Marge Schmuckal - Sidewalk sign application - 2014-00060 - 046-D-031

From: Marge Schmuckal
To: flick18park@gmail.com
Date: 1/14/2014 11:32 AM
Subject: Sidewalk sign application - 2014-00060 - 046-D-031

27" x 46"

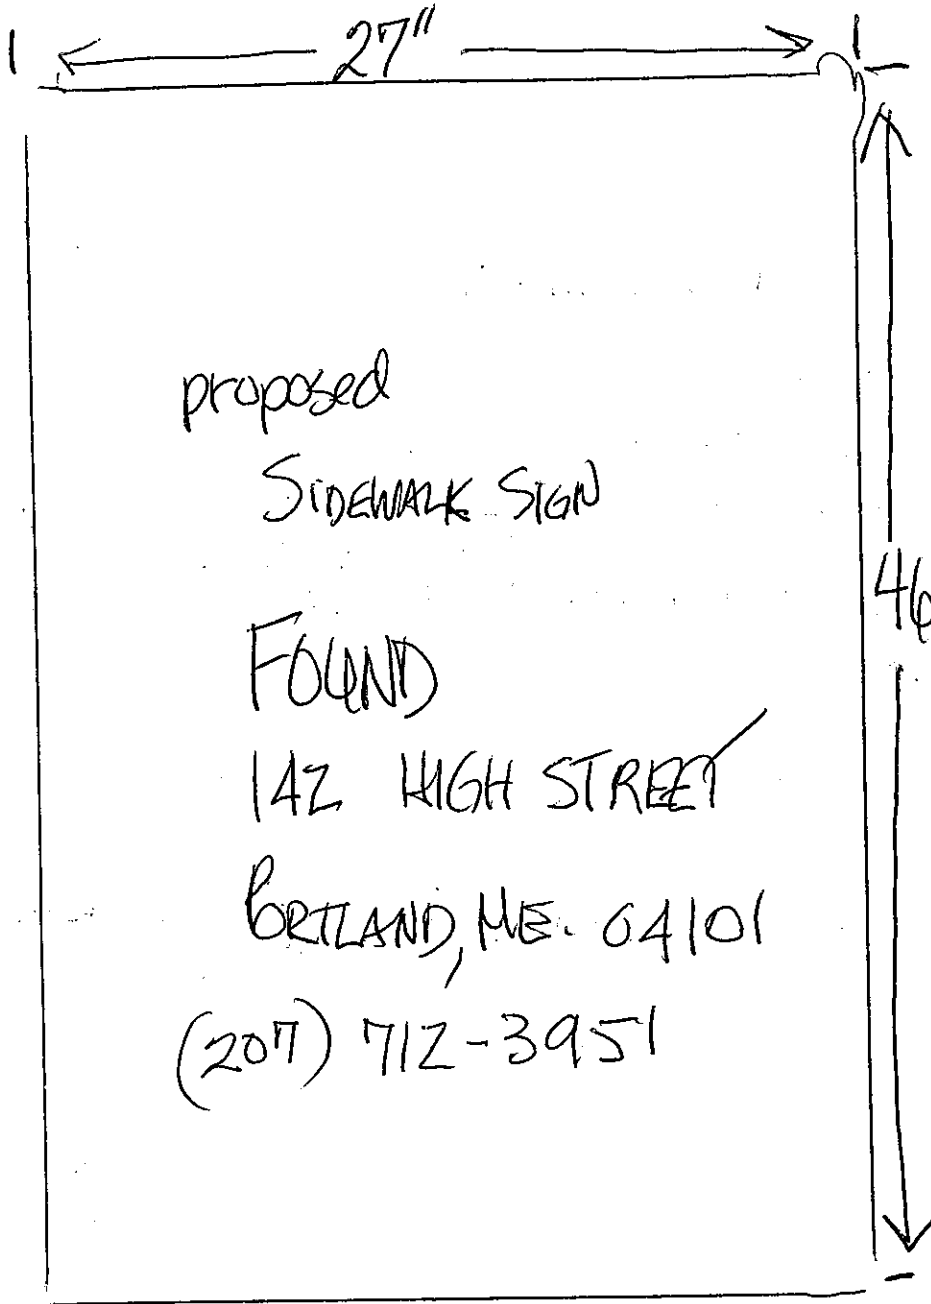
I am reviewing your application for a sidewalk sign. One of the requirements for such signs is that the maximum height in place is 40 inches. the only dimension that you gave us is that the actual sign is 46 inches in height.

Can you give me confirmation as to the height of your sign when it is in place?
